Addendum No.1

RE: Contract ID: C202110

New Hanover, Brunswick Counties (F-5002)

Southport and Fort Fisher Ramp-Gantry Paint and Rehabilitation.

END RAMP REPAIR
 SOUTHPORT AND
 FORT FISHER

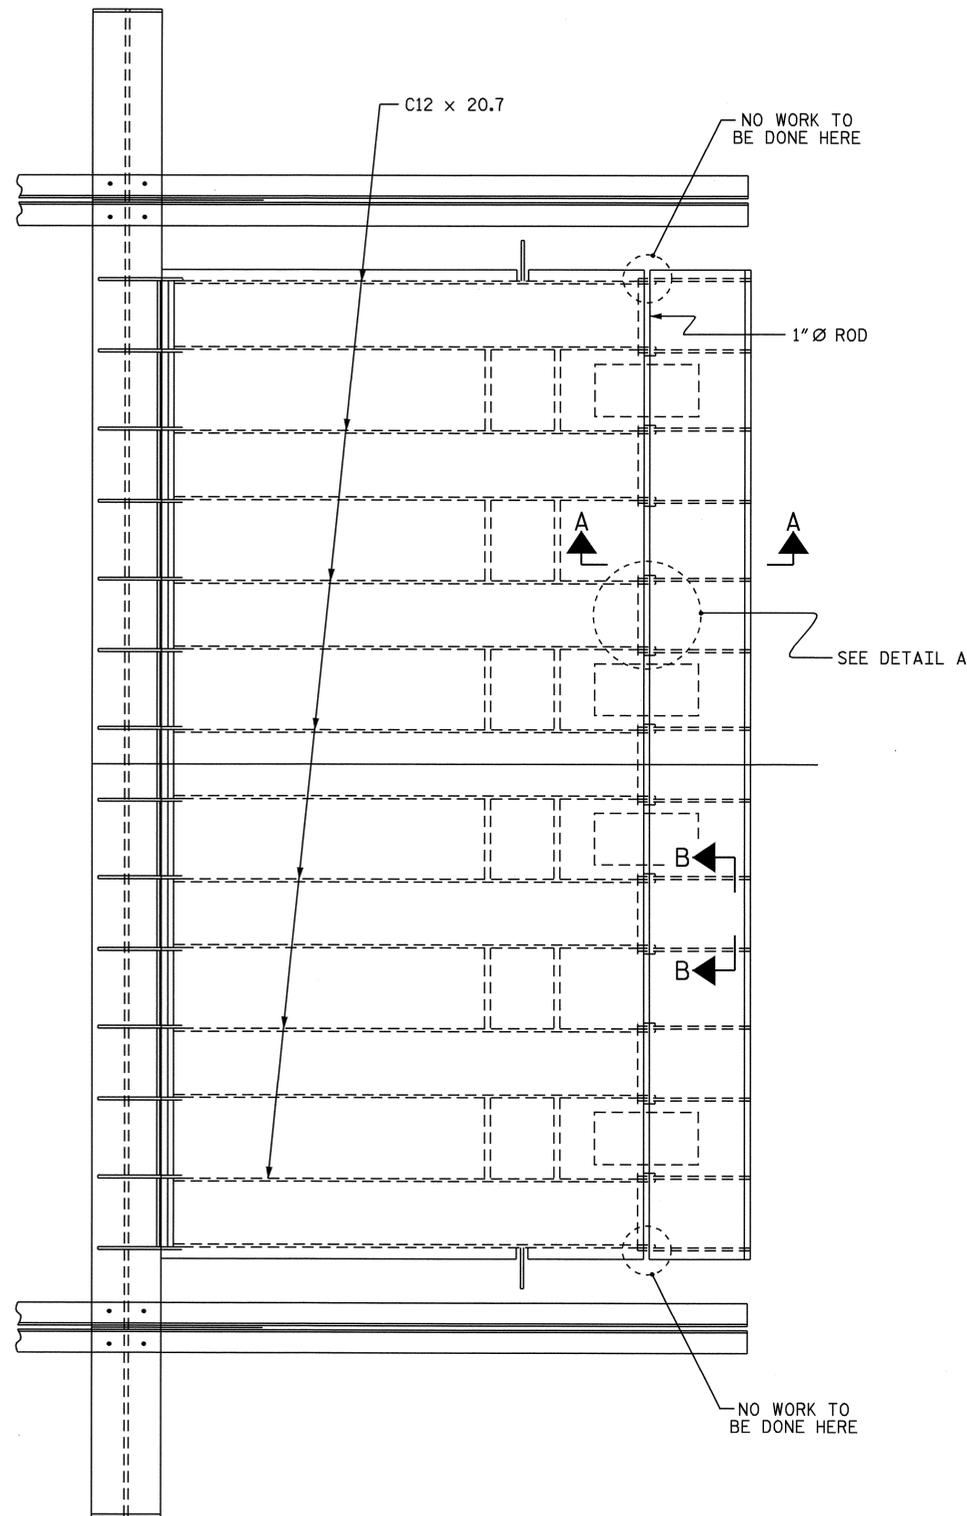
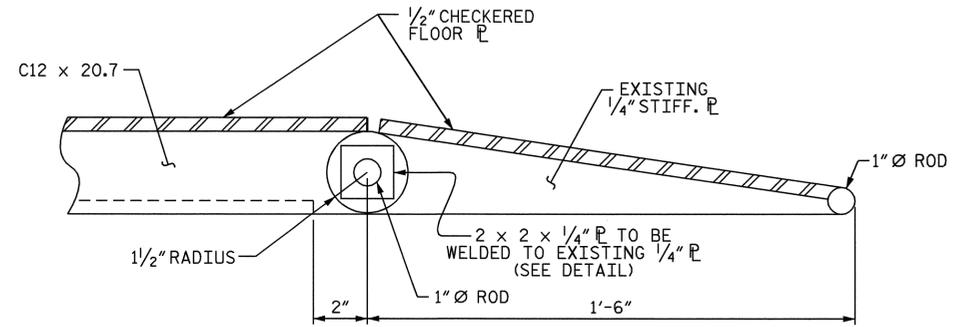
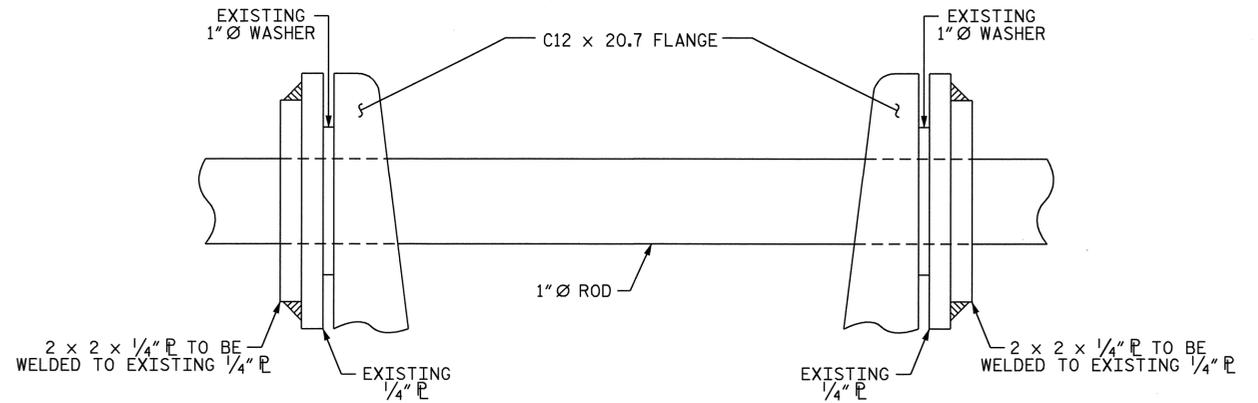
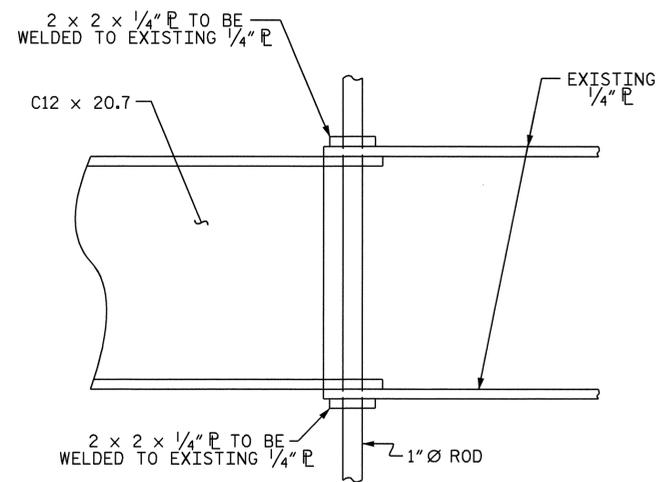
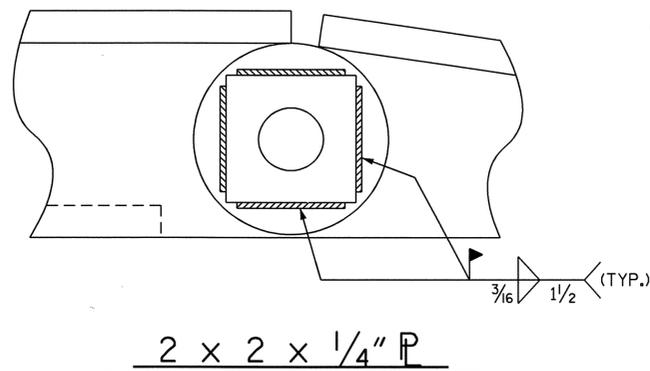
On Page No. 30 the Project Special Provision entitled "REPAIR OF EXISTING RAMP END" has been revised, the word inorganic has been changed to organic. Please void Page No. 30 in your proposal form and staple the revised Page No. 30 thereto.

The work covered in this special provision consists of repairing the 1-foot 6-inch ramp end. The holes for the existing 1 inch diameter rod in the existing ¼-inch gusset plate have enlarged and a proposed ¼-inch plate shall be welded to the existing ¼-inch gusset plate as detailed in the plans. The proposed plate may be field welded according to Section 440-7 of the Standard Specifications. The welded plates shall then be painted with a coat of organic zinc primer meeting the requirements of 1080-8 of the Standard Specifications with a 3-5 mil DFT. The ramp end shall have 2 coats of aluminum mastic epoxy paint to match the completed ramp. The repair shall in no way impede the intended function of the ramp. The Contractor is responsible for proper operation of the completed ramp.
